To: City of Mercer Island – Plans Reviewer
Subject: Remodel – 5330 Butterworth Rd.
Building Permit # 2405-053

Thank you for reviewing our permit submittal. Below is a narrative of the plan updates and responses to the review comments we've received.

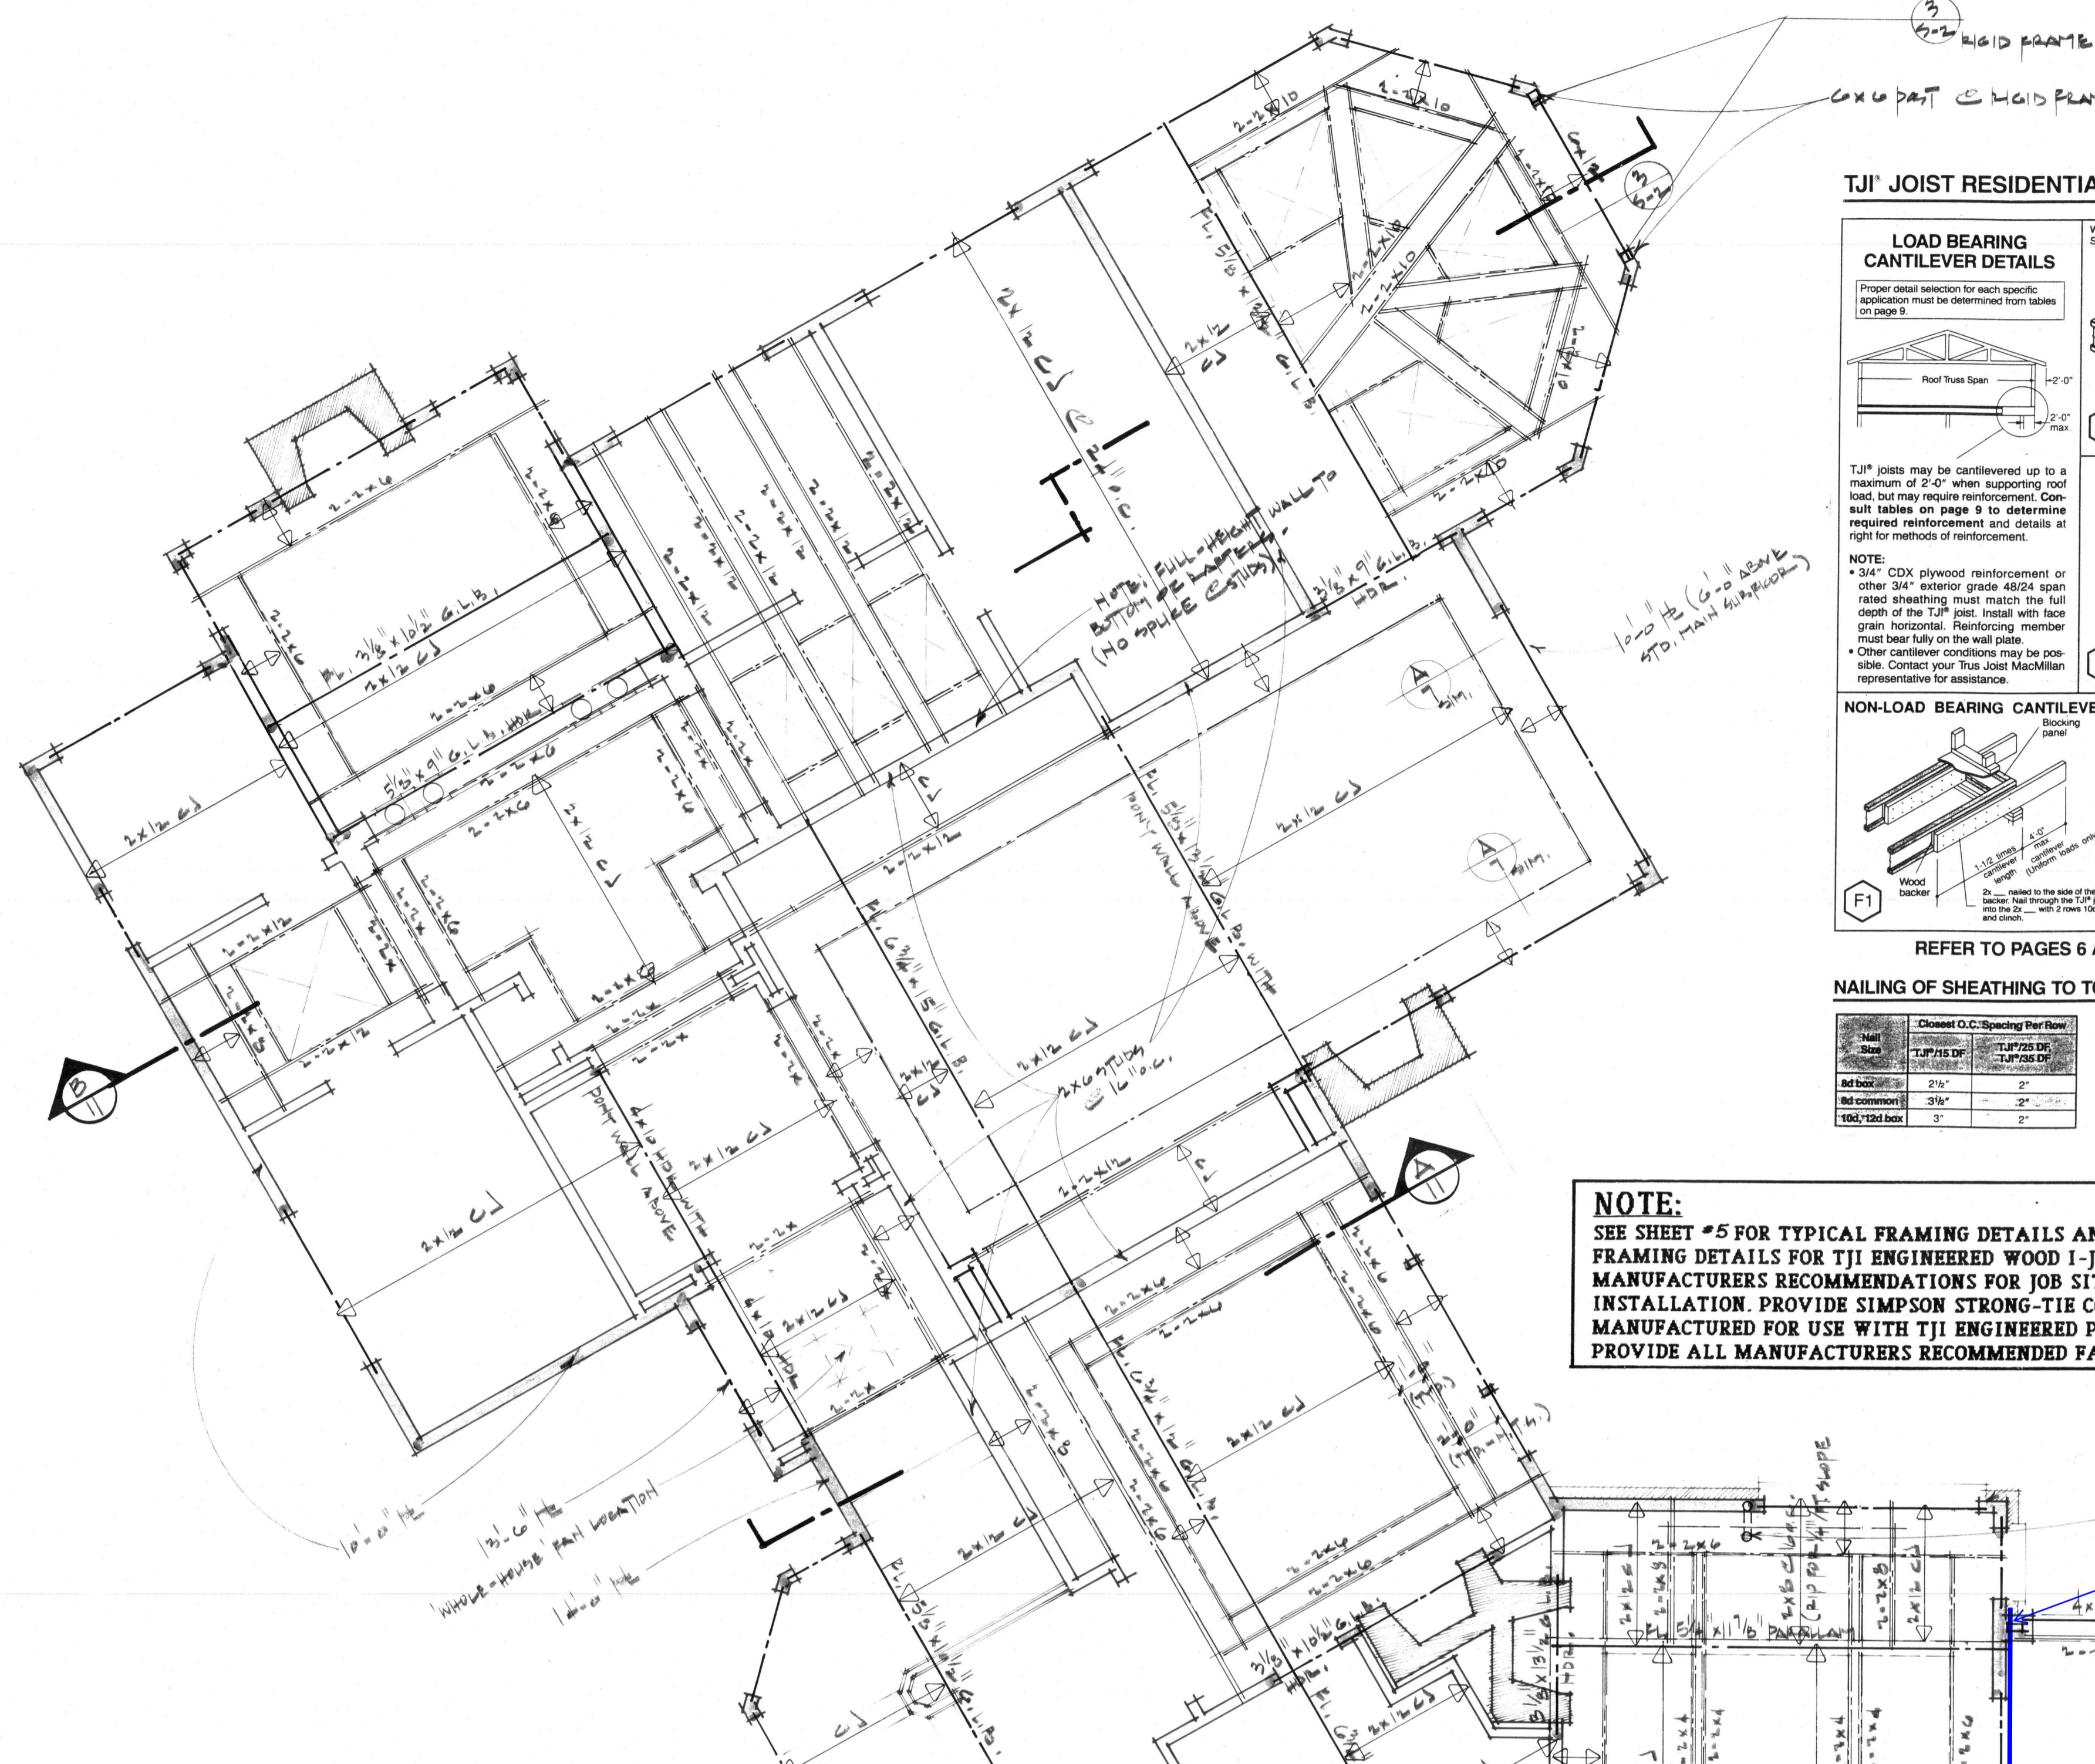
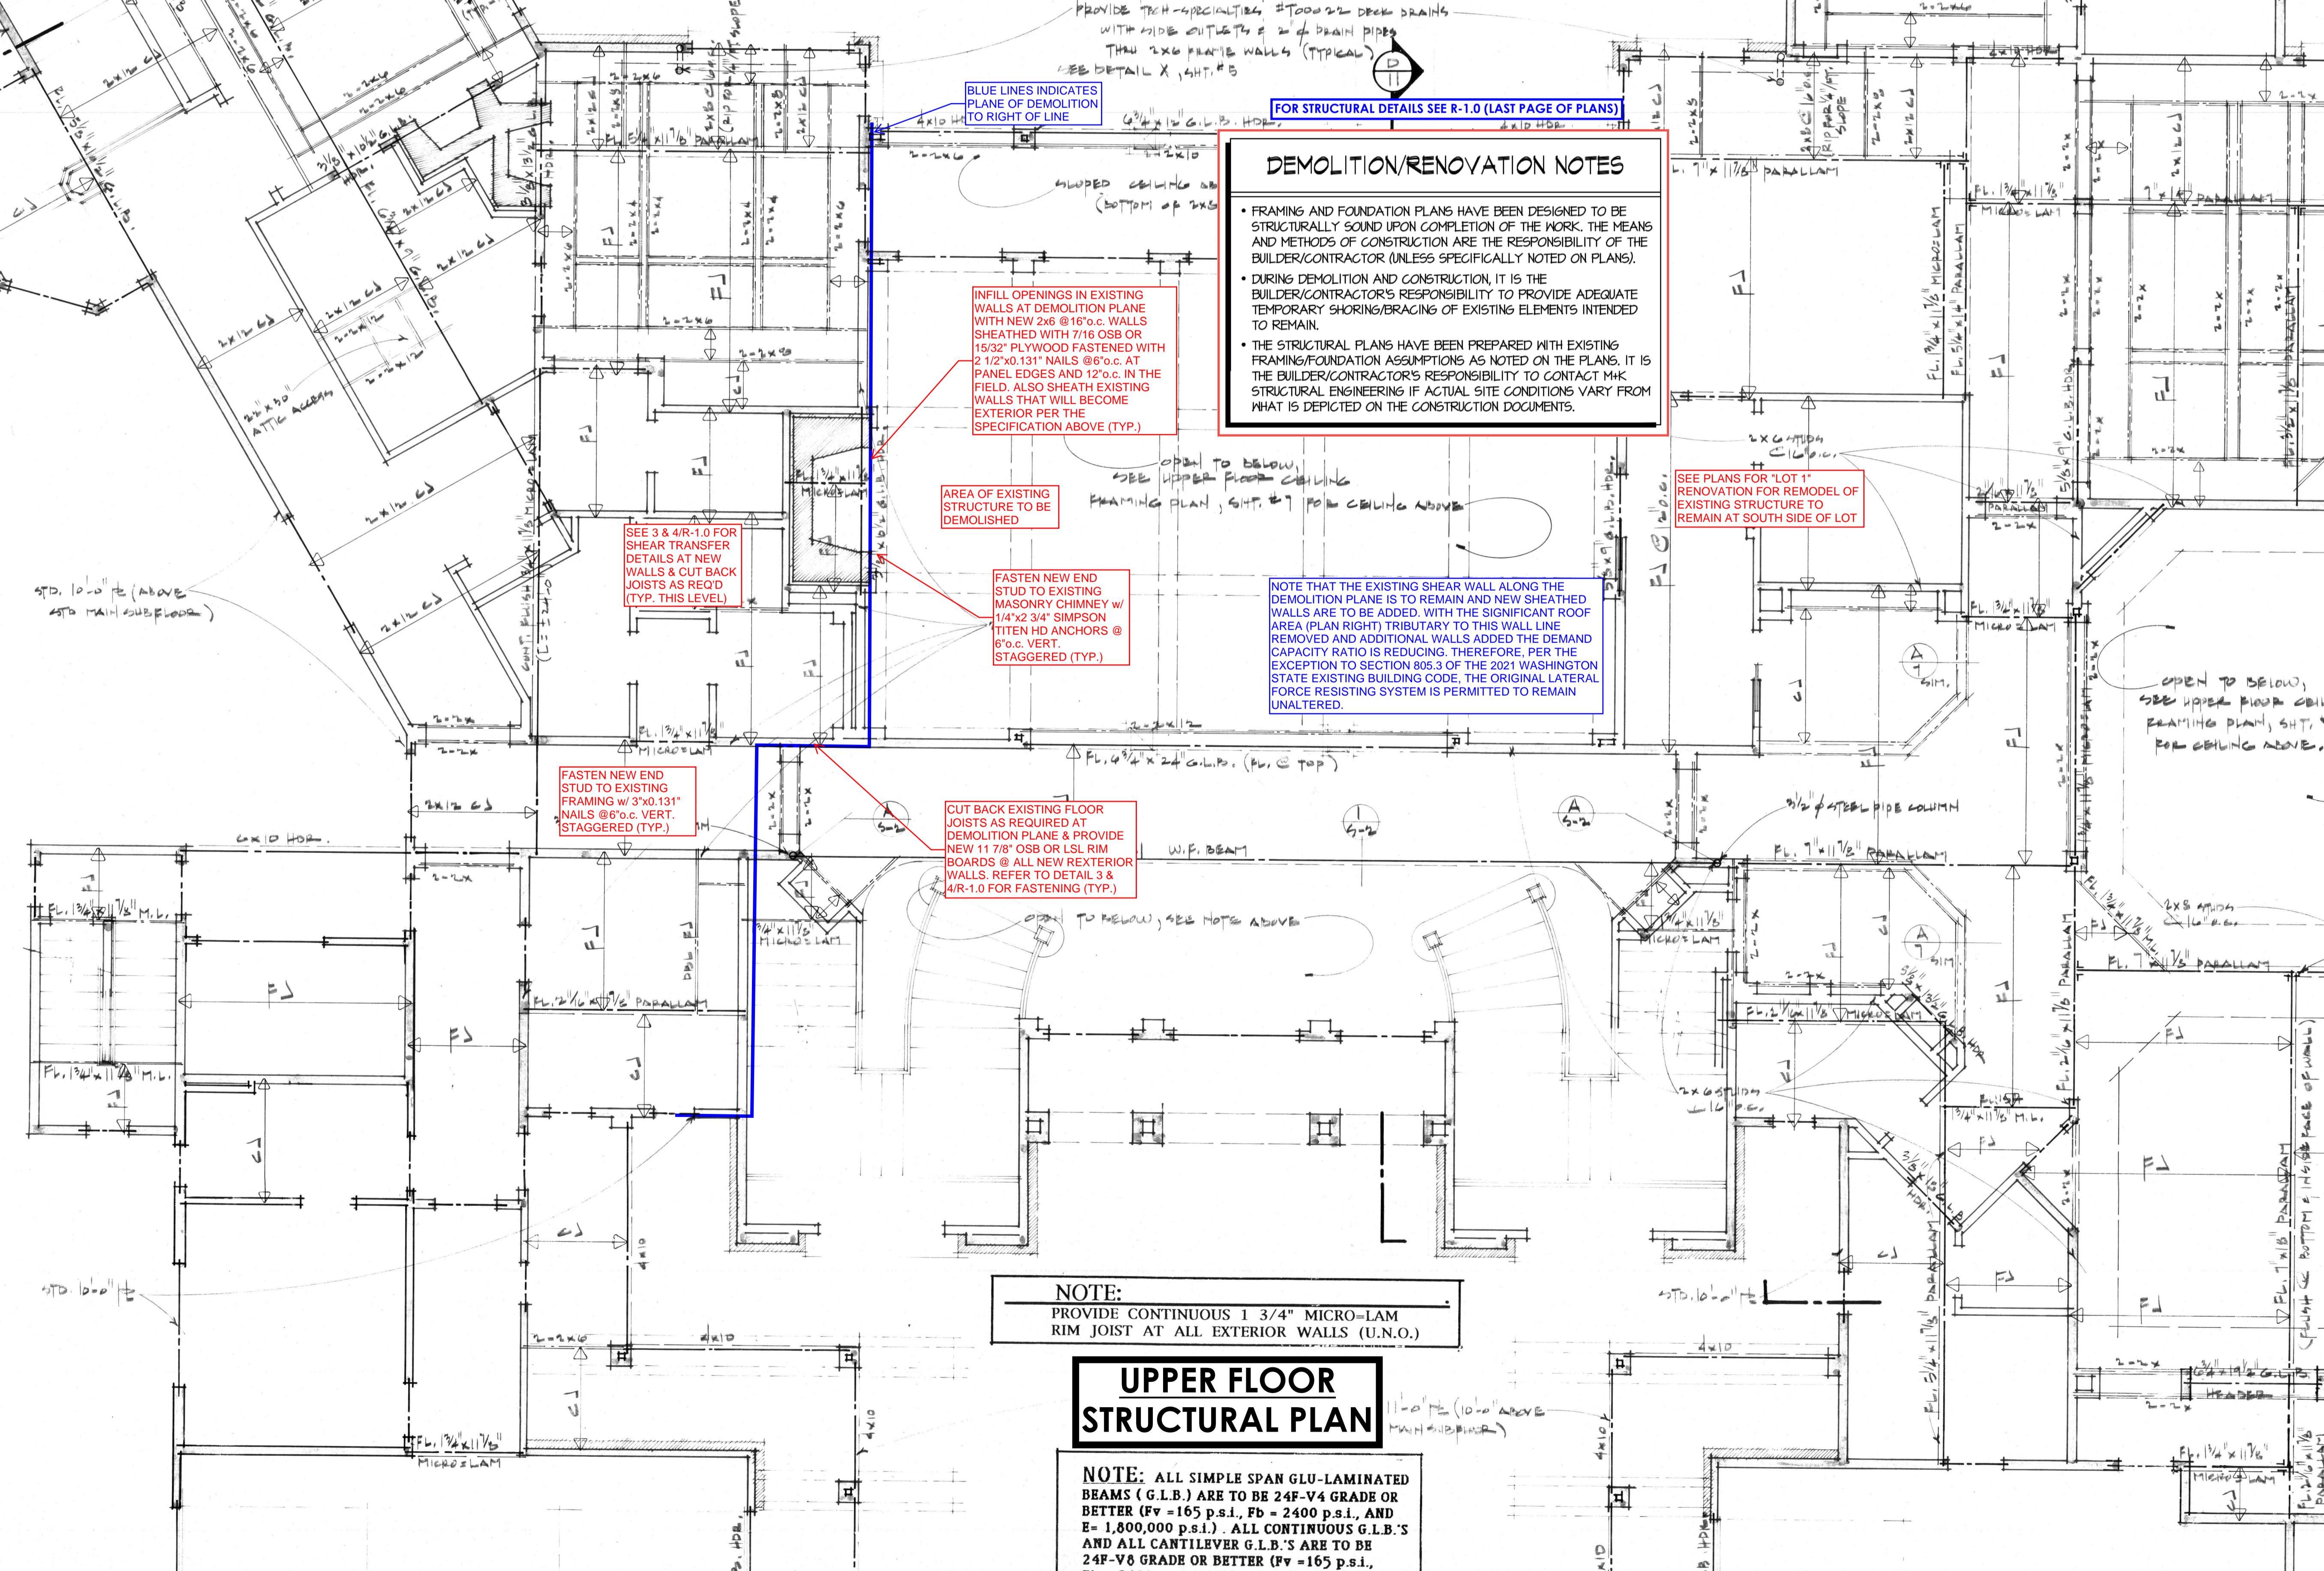
2) The project appears to divide the existing residence into two structures. Provide complete floorplans for the entire residence to scope the project (if where there are no changes to the north wing, mark rooms as existing to remain or not in scope). Provide complete details for the, structure, enclosure, insulation, and weatherproofing of the remaining north structure including lateral design if appropriate. Site plan provided does not describe the final condition... the site plan A1.0 at the end of the set shows features to be demolished.

[RESPONSE: Full plans for the existing house have been uploaded to the portal with notes and markups indicating scope of work. Structural details and notes have been provided indicating final condition.](#)
